Recommendation Report for Planning Permission for Works or Extension to a Dwelling

REF NO: AW/422/21/HH

LOCATION: 24 Lincoln Avenue
Aldwick
PO21 3EJ

PROPOSAL: Single storey rear extension and first floor dormer.

Proposed Rear Extension
Plans and Elevations
Planning

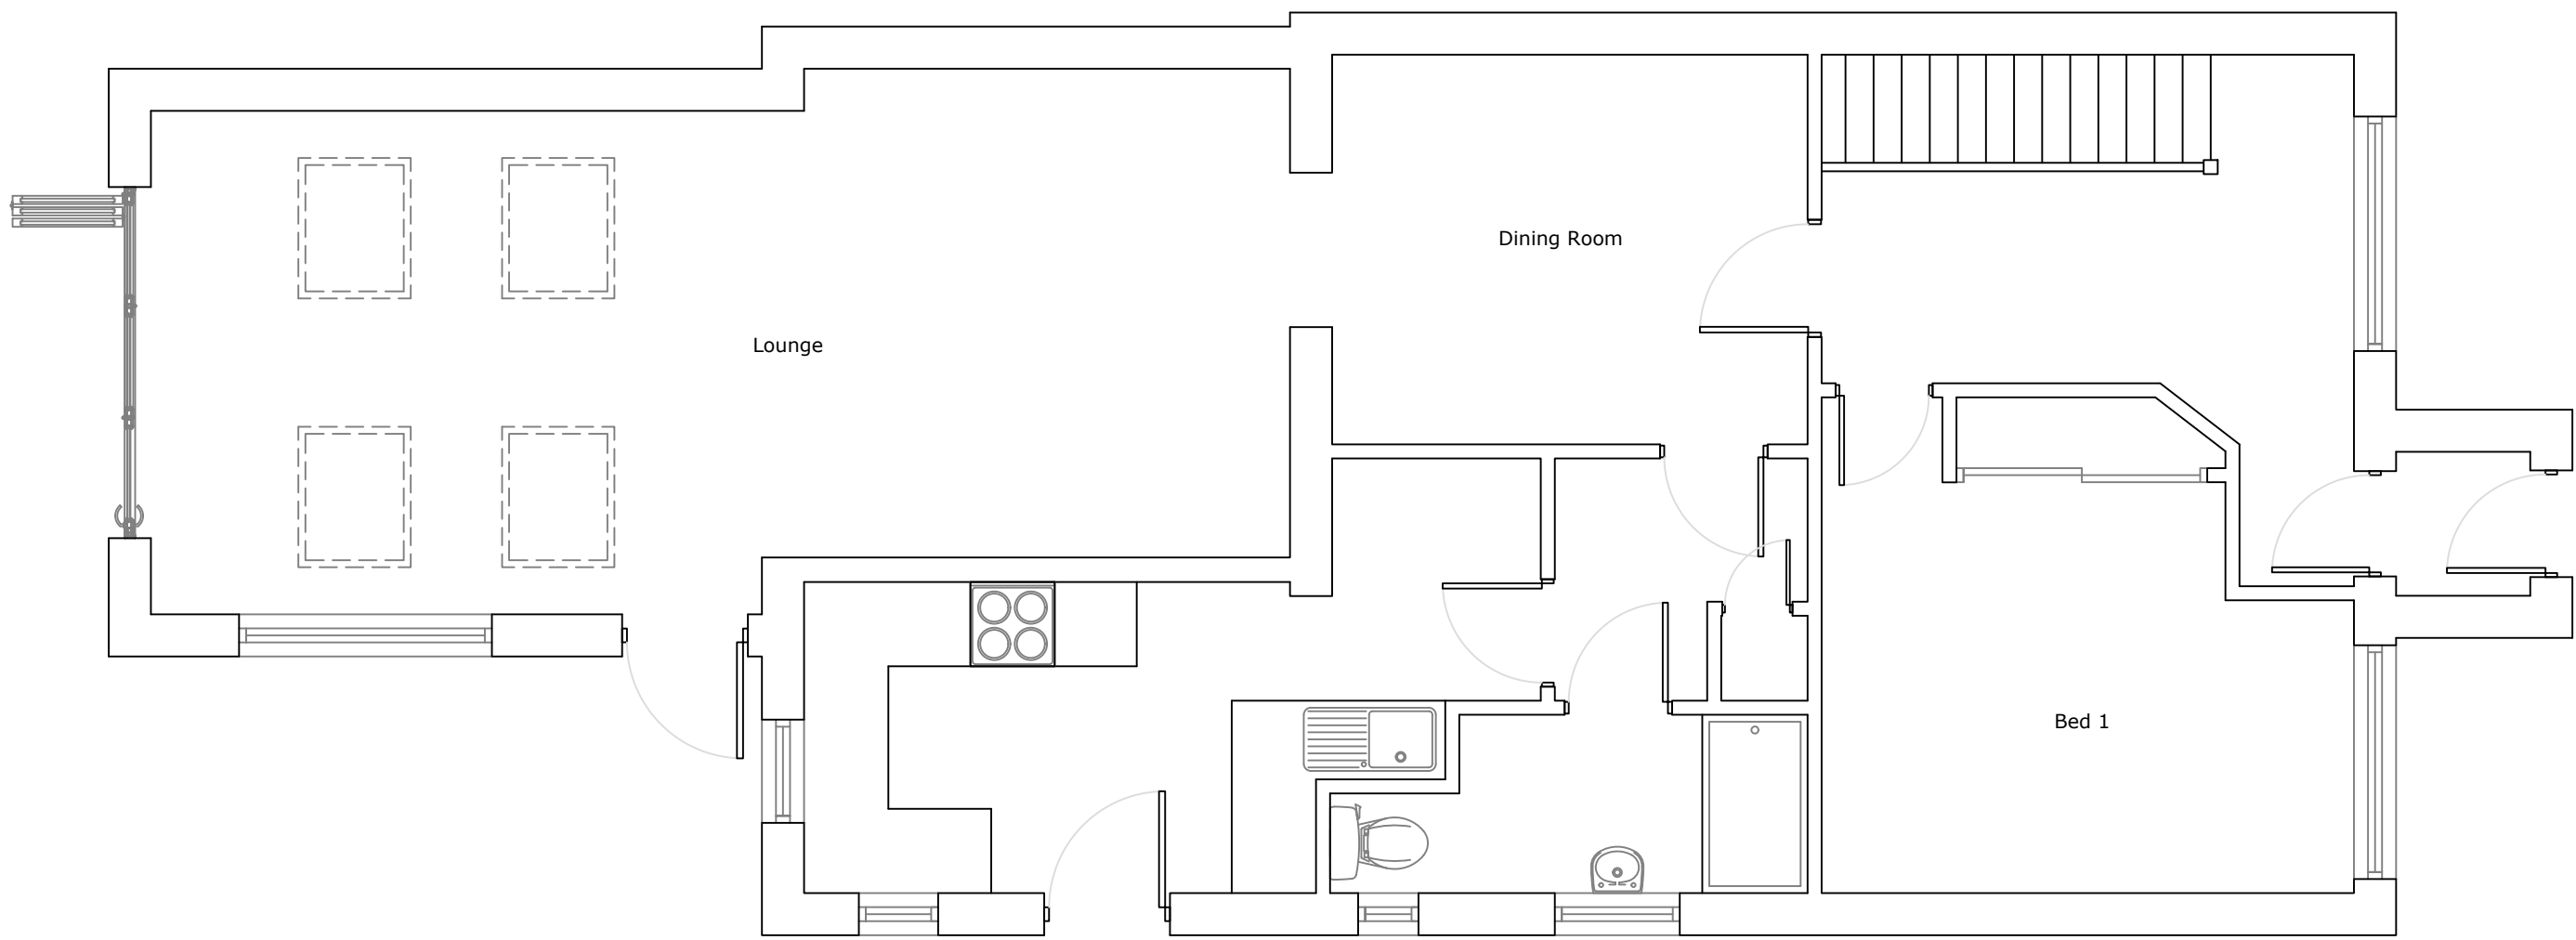
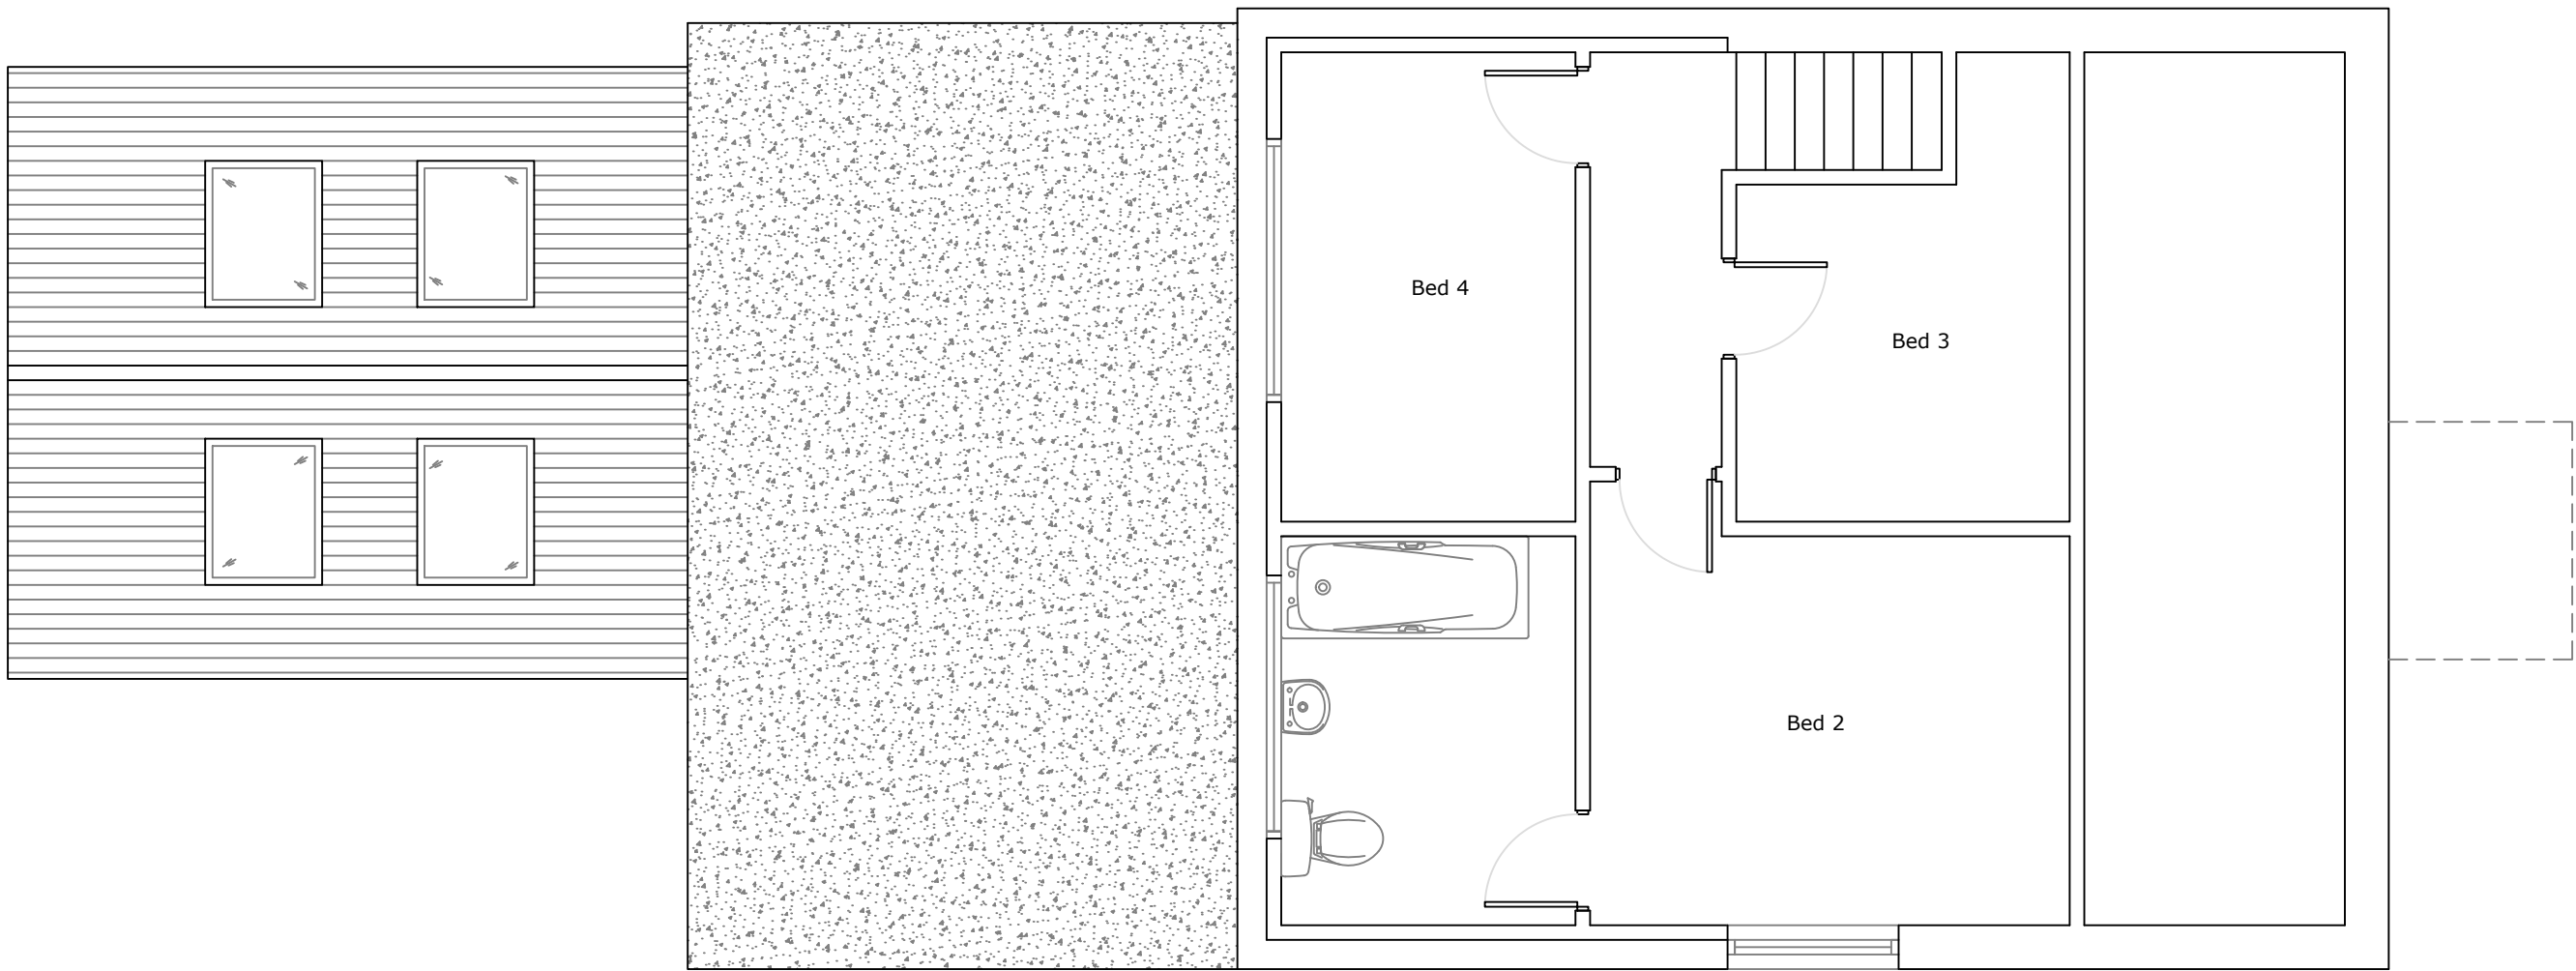
The extension will replace a conservatory although will not increase in depth or width. The roof will be pitched. With no viewpoints available from the street scene its design is considered acceptable and in scale with the host dwelling.

The rear extension will have a depth of 4.5m. This does join with an existing addition and the total depth from the rear of the dwellinghouse would be 8.3m. This does extend some distance beyond the rear of the host dwelling however both neighbouring dwellings have extensions and the property to the north at No.26 extends to the same as that proposed. The proposal will slightly intersect a 45 degree angle from the neighbour at No.22 although this does not alter from that which exists with the extension replacing a structure. The proposal will not result in additional adverse overbearing or overshadowing.

The extension will have a pitched roof to a height of 3.3m. This will be more visible from the neighbouring side however the alteration to the design of the roof does not result in adverse harm with the roof sloping away from the boundary and the height matching that of the height of the existing conservatory.

Around 5m is retained to the northern side boundary and there will be a door and window to this elevation. The openings are similar to that which exist and will provide views over the garden of the host dwelling. There will be 4 rooflights to the extension although due to the height above finished floor level views will not be achievable.

A dormer will be located to the rear roof slope and have a height of 2.5m, a depth of 3m and a length of 6.3m. This sits comfortably within the roof slope and will not give rise to overbearing being contained within the existing footprint.

The dormer will have 2 windows serving a bathroom and a bedroom. There is a small dormer already although due to the size of the dormer and due to the siting of the property to the rear at No.37, it is acknowledged that the new dormer will give rise to overlooking on the garden which is not currently achievable. A dormer of this size is likely allowed under permitted development and therefore overlooking could be a reason for refusal. Both neighbouring dwellings have dormers and views would
